Response to submissions – St George Stage 2, Acute Services Building

Gray Street No. 33-41 - existing SGH shadow

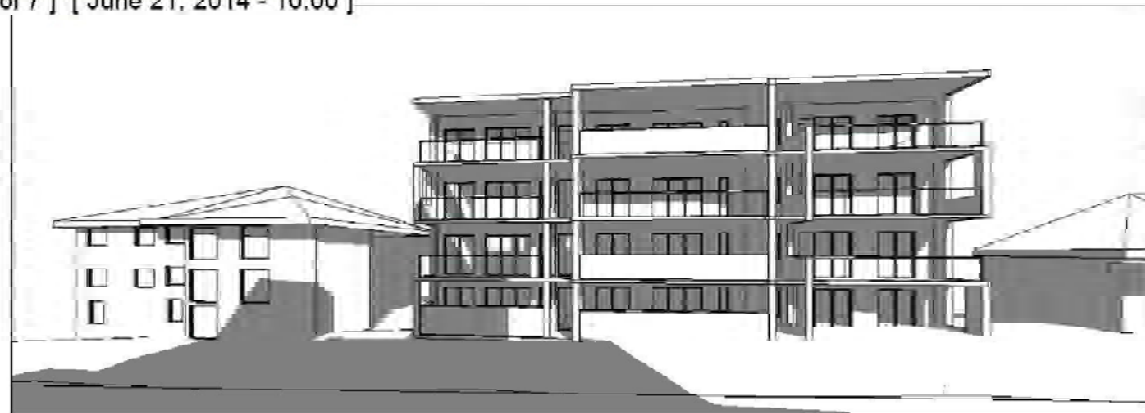
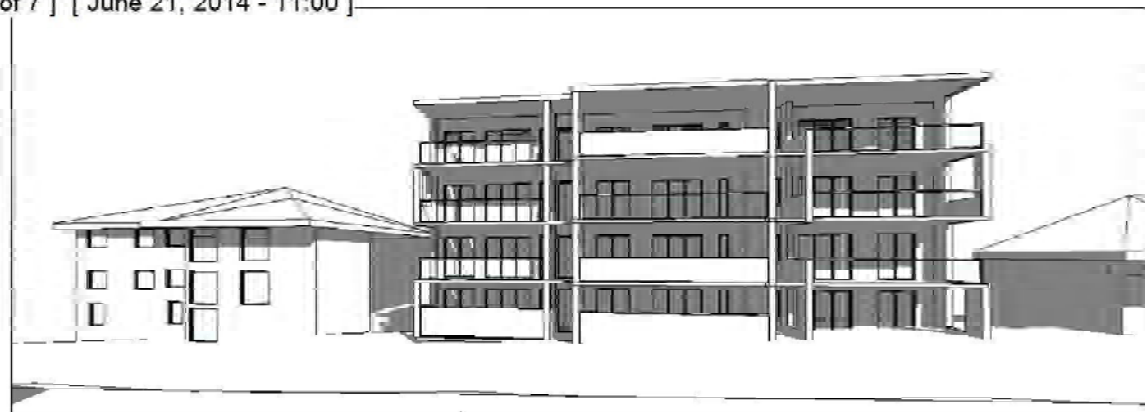
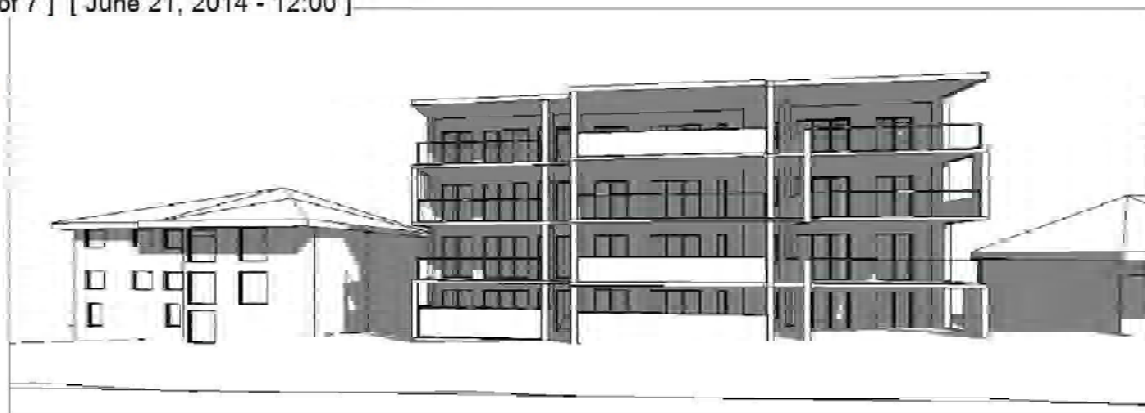
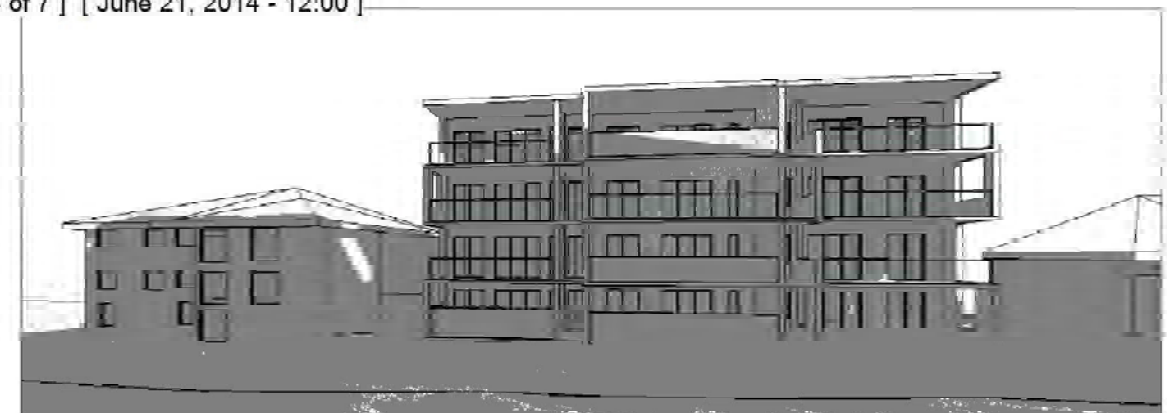
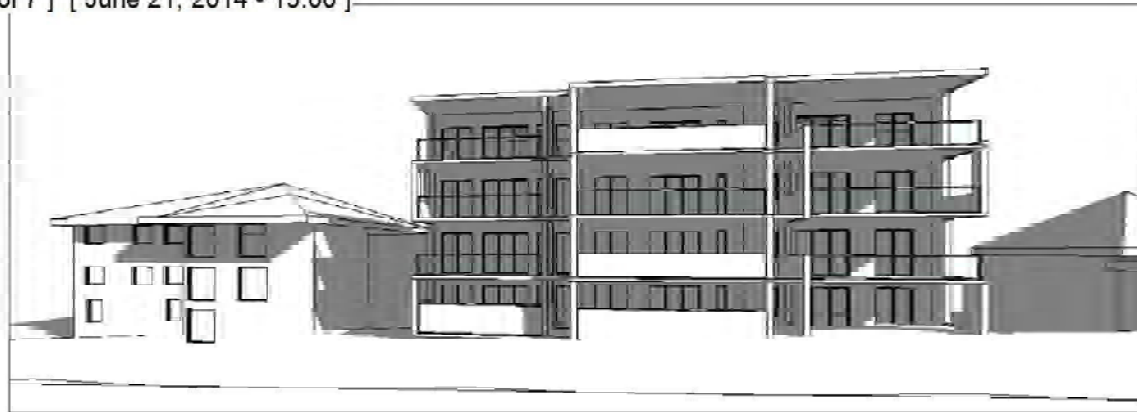
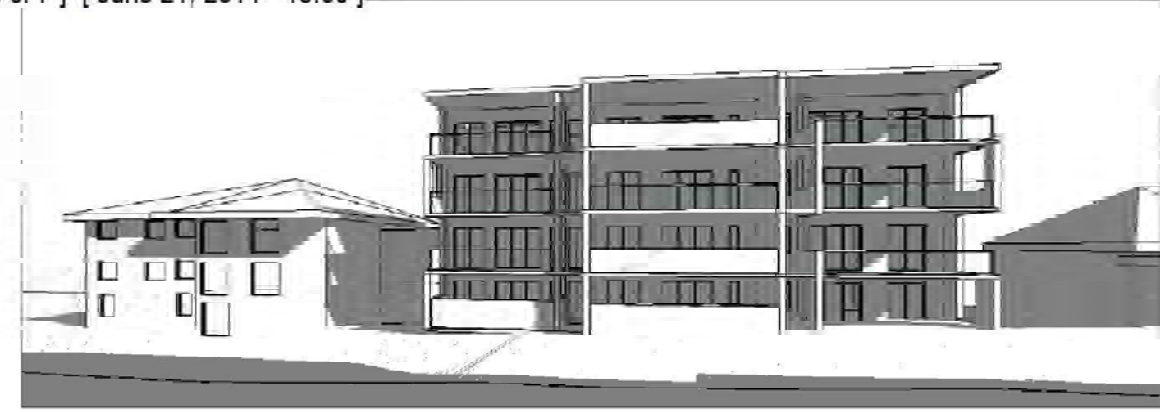
Agency/Private	Submission/Comments	Proponent's Response
DPE	Further justification be provided regarding the overshadowing impacts on adjoining residential development with consideration of the access to sunlight planning principle, including providing further detailed analysis of the level of impact on affected living rooms and private open space areas.	<p>Health Infrastructure's architects have conducted a detailed solar study of the properties impacted by potential loss of sunlight as a result of the construction of the ASB. This study looked at the impact on habitable windows and private open space. Private open space is defined in the Standard Instrument – Principal Environmental Plan as <i>"an area external to a building (including an area of land, terrace, balcony or deck) that is used for private outdoor purposes ancillary to the use of the building"</i>. For the purposes of the solar study it was considered as balconies in residential flat buildings and rear yards in houses, which is consistent with this definition.</p> <p>The <i>Apartment Design Guide</i> (Department of Planning and Environment, 2015) provides a guideline for apartment builders to comply with SEPP65. In terms of solar access it states that living rooms and private open spaces of at least 70% of apartments in a building should receive a minimum of 2 hours direct sunlight between 9am and 3pm at mid-winter in the Sydney Metropolitan Area.</p> <p>The properties analysed were the existing dwellings (houses and flat buildings) along Gray Street and Ocean Street.</p> <p>Summary of the Findings</p> <p>The results of the analysis show that while a number of properties lose some sunlight to habitable rooms in midwinter as a result of the proposed ASB, no property has less than three (3) hours of sunlight to areas of private open space.</p>

Agency/Private	Submission/Comments	Proponent's Response
		<p>33-37 Gray Street Eleven (11) units within the building at 33-37 will receive no sunlight to "a habitable room" (based on window locations) during the period 9am to 3pm on 21 June. Of these properties two (2) receive no sunlight under existing conditions and eight (8) lose the one hour they would have received. Unit 17 loses one (1) hour but still retains one (1) hour. Unit 15 loses two (2) hours.</p> <p>All of the units within this building lose one (1) hour of sunlight from their private open space but maintain at least three (3) hours of sunlight midwinter.</p> <p>39-41 Gray Street The units within this block lose between one (1) and two (2) hours sunlight to their habitable room windows but all retain a minimum of two (2) hours sunlight following development of the ASB. None of these units will lose sunlight to their private open space retaining the three (3) hours they already receive</p> <p>Other properties in Gray Street. Of the eight (8) properties impacted by the proposed ASB, all but three (3) (27, 29 and 31 Gray Street) will retain more than two (2) hours sunlight to their front windows. All of these properties have shading devices (either verandahs or shade hoods over their windows. 27 Gray Street is owned by NSW Health and is not used as a residence.</p> <p>All of the houses in Gray Street retain in excess of three (3) hours of sunlight to areas of private open space.</p> <p>Properties on Ocean Street The ASB will overshadow properties from 6 to 24 Ocean Street at 9am at midwinter however the shadow has largely moved on</p>
